**RE: McMahon Market Place Lots 9C&D
Grading and Drainage Plan
Stamp Date: 6/27/17
Hydrology File: A11D011F**

**RE: McMahon Marketplace Lots 9C and D; Grading and Drainage Plan Resubmittal
Hydrology File: A11D011F**

Included with this response is a copy of the revised Grading and Drainage Plan for the above referenced project. Revisions were made based on your review comments dated June 19, 2017. Following are numbered responses corresponding to your numbered comments:

SHEET NO:  
C-1

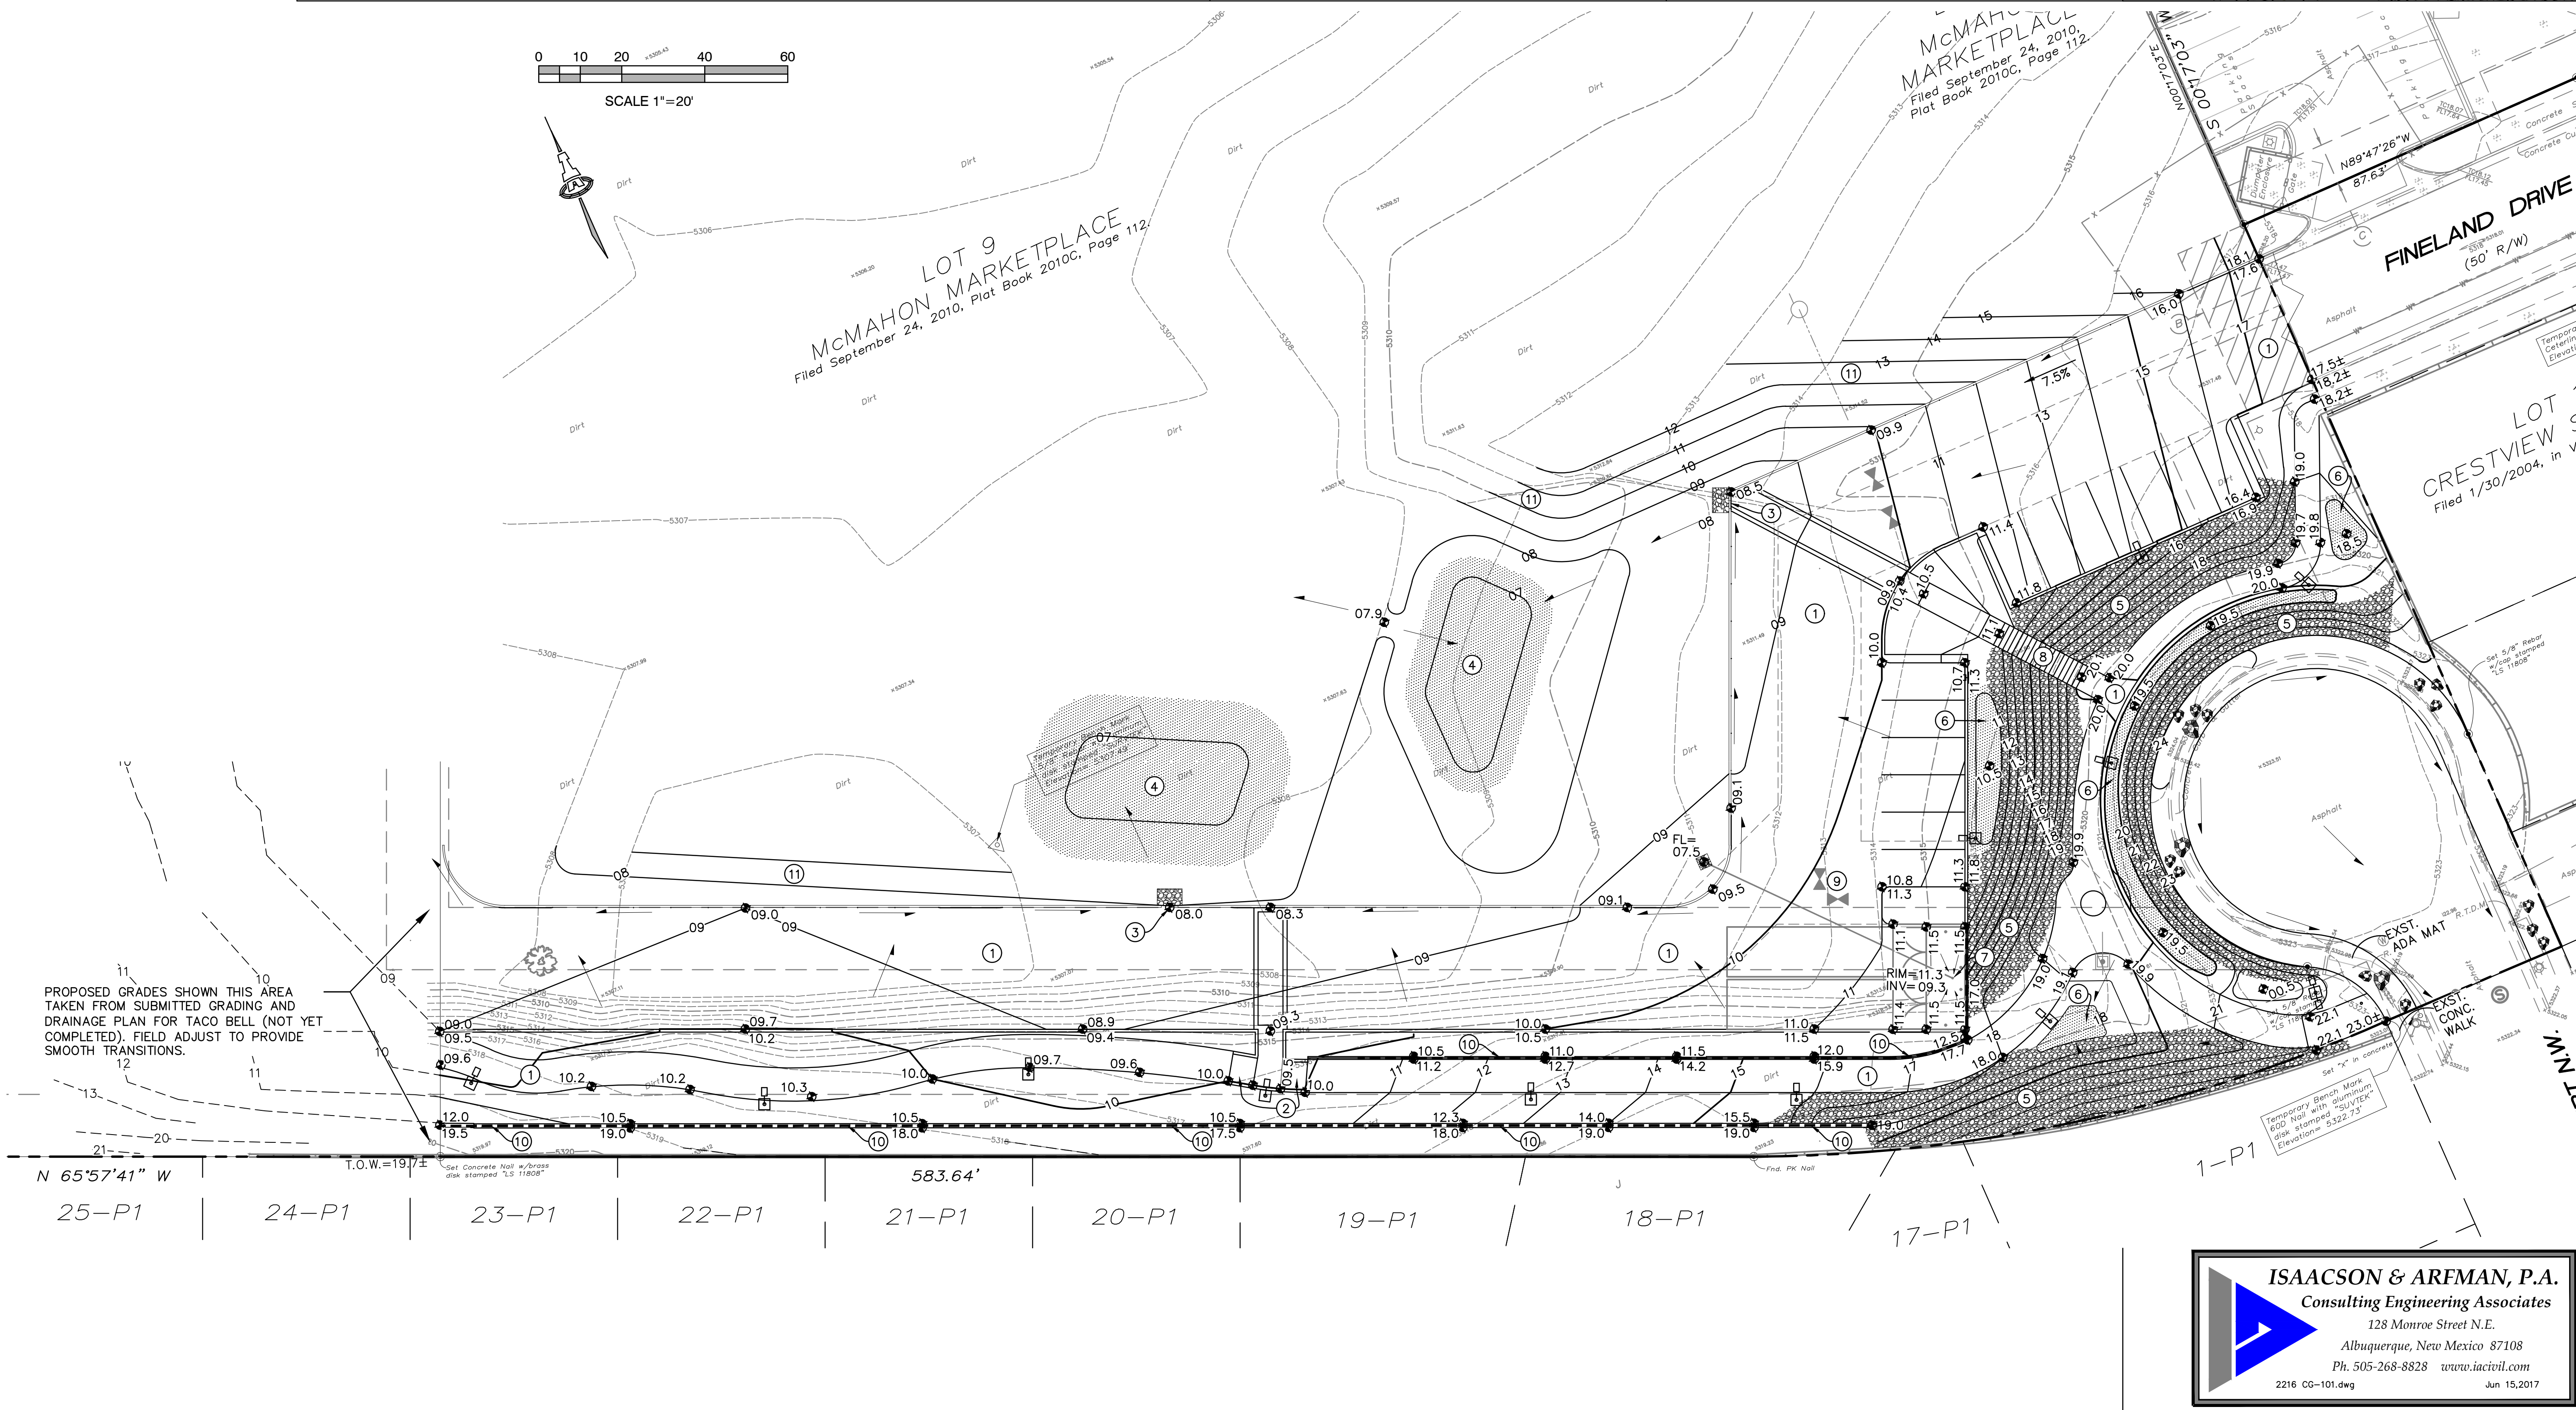
1. An Erosion and Sediment Control Plan will be submitted to the storm water quality engineer.
2. Vicinity Map updated.
3. At the time the survey was created, the Taco Bell had not begun construction. We have utilized the Grading and Drainage Plan design available in the COA Hydrology files to coordinate. See Exhibit attached for Hydrology approved (temporary) Engineer's Certification which shows coordination. We have also modified note in that area to read:
Proposed grades shown this area were coordinated with the approved grading and drainage plan for Taco Bell. Minor field adjustments may be required. Match and provide smooth transition to existing retaining wall top and bottom elevations, existing sidewalk and curb & gutter. Field adjust to provide smooth transitions.

4. Cross section of the proposed retaining wall added.
5. Maximum retaining wall height limited to 8.0'.
6. Keyed note #3 calls out the 6' wide x 4' long x 1' deep erosion protection at each curb opening.
